Queen Camel, West Camel and Sparkford Parish Councils

4th August 2020

A303 Sparkford to Ilchester Dualling Scheme.

FIGURE 2.5  
HAZLEGROVE JUNCTION UNDERBRIDGE  
GENERAL ARRANGEMENT

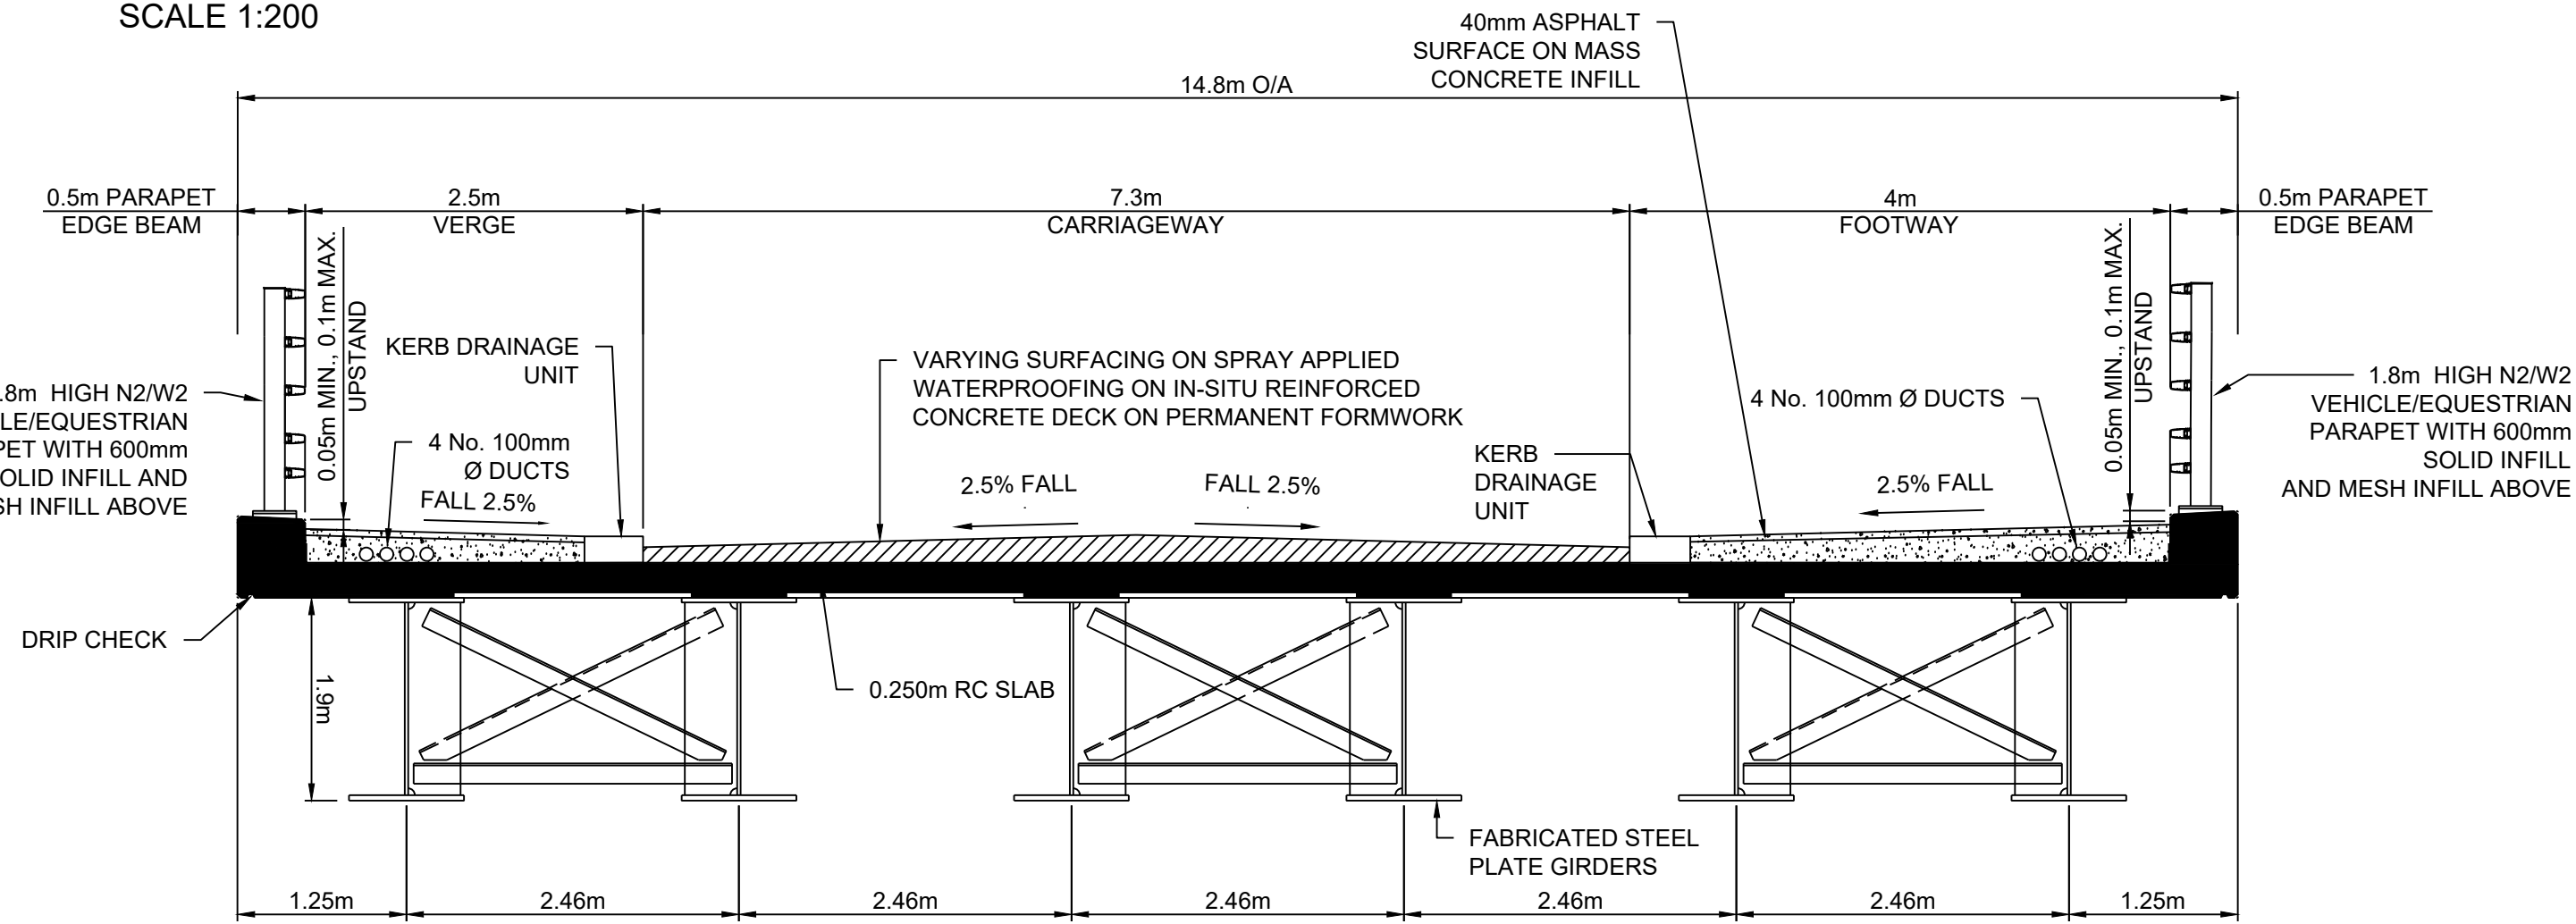
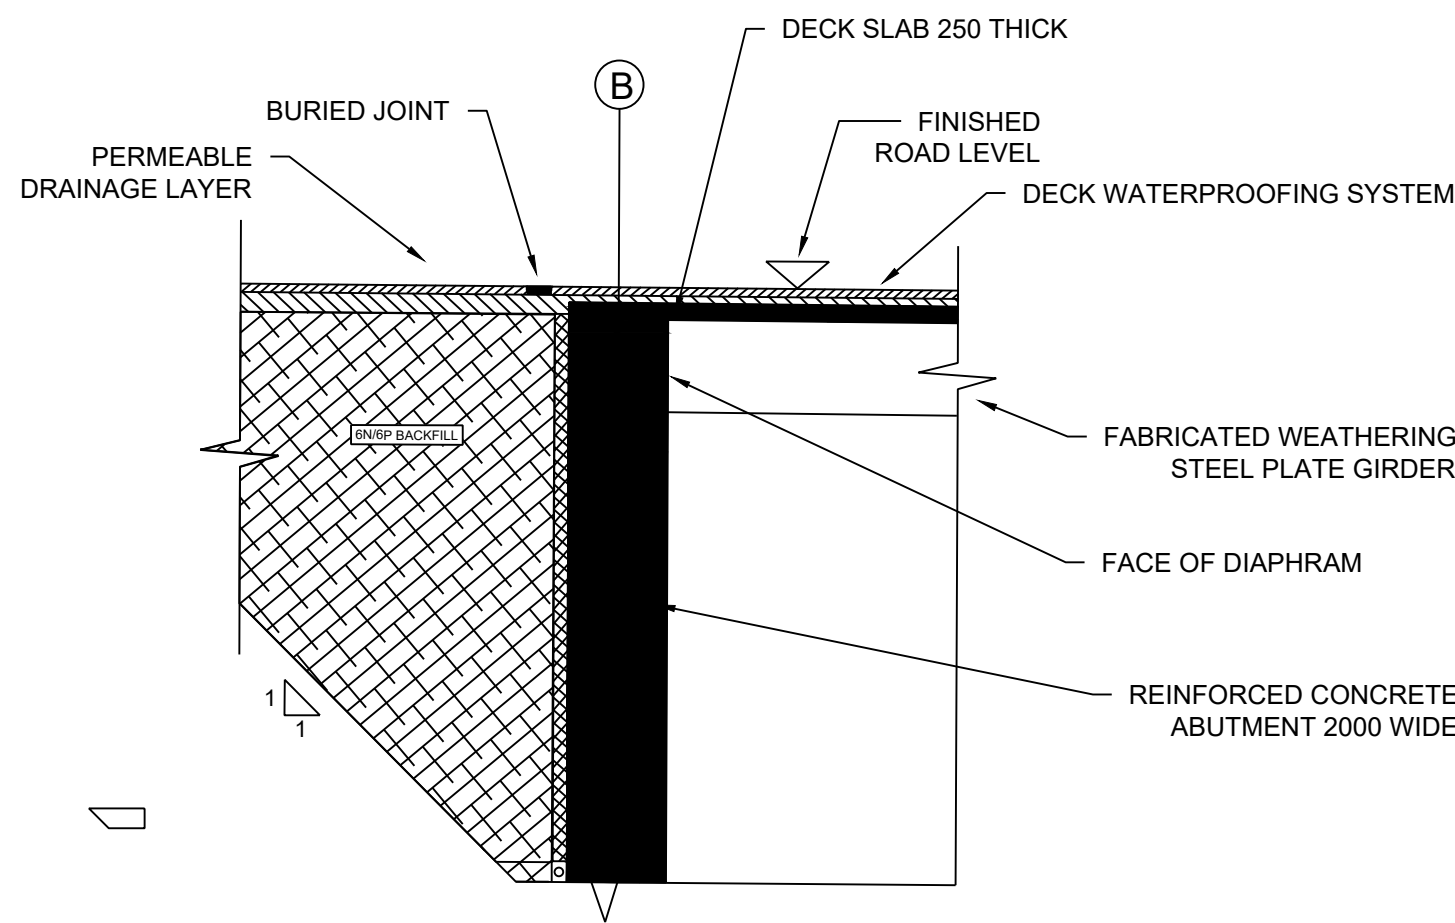
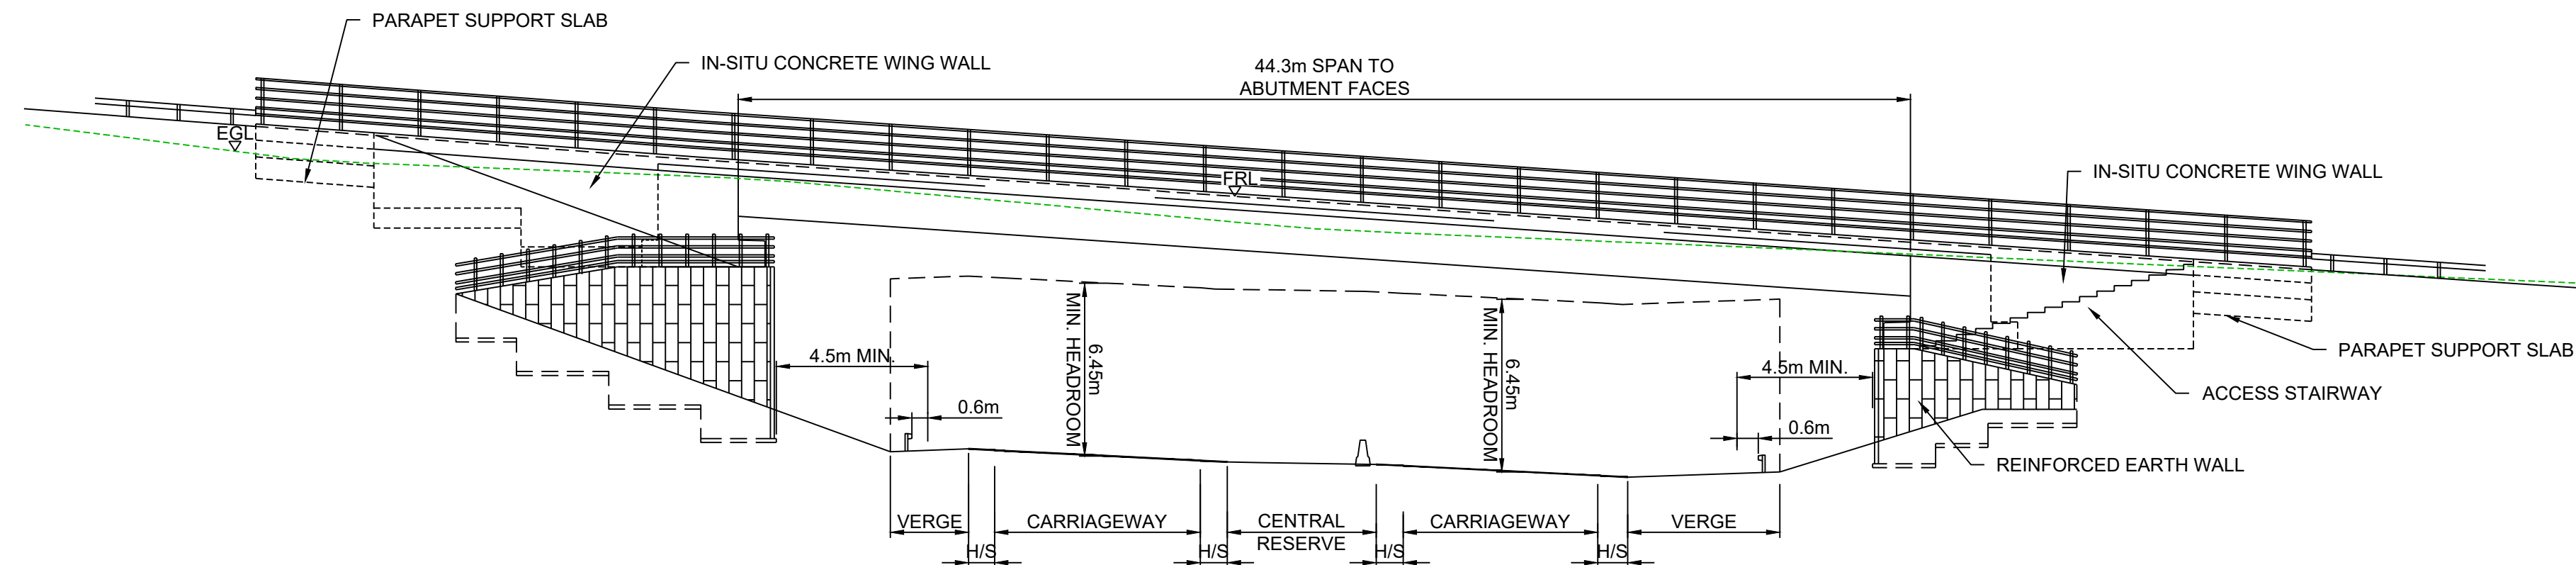
One single area the PCs would like to bring to the Ministers attention, is our serious concern about the environmental and road safety consequences of the poor design of the Hazlegrove junction.

1. HE ignored answering the question asked by the PI in Action 12, 2.4.3, relating to traffic at the East on road slip. HE's comments related to the school turning, where no problem exists. The East on slip turn is where the problem will be, with peak hour congestion and safety issues being created. This is fully explained in Mr Bryan Norman's reply of 22 November to the DoT's letter of 5 November 2019.

We believe that the HE proposals for the Hazlegrove junction are not in accordance with NNNPS regarding safety and good design.
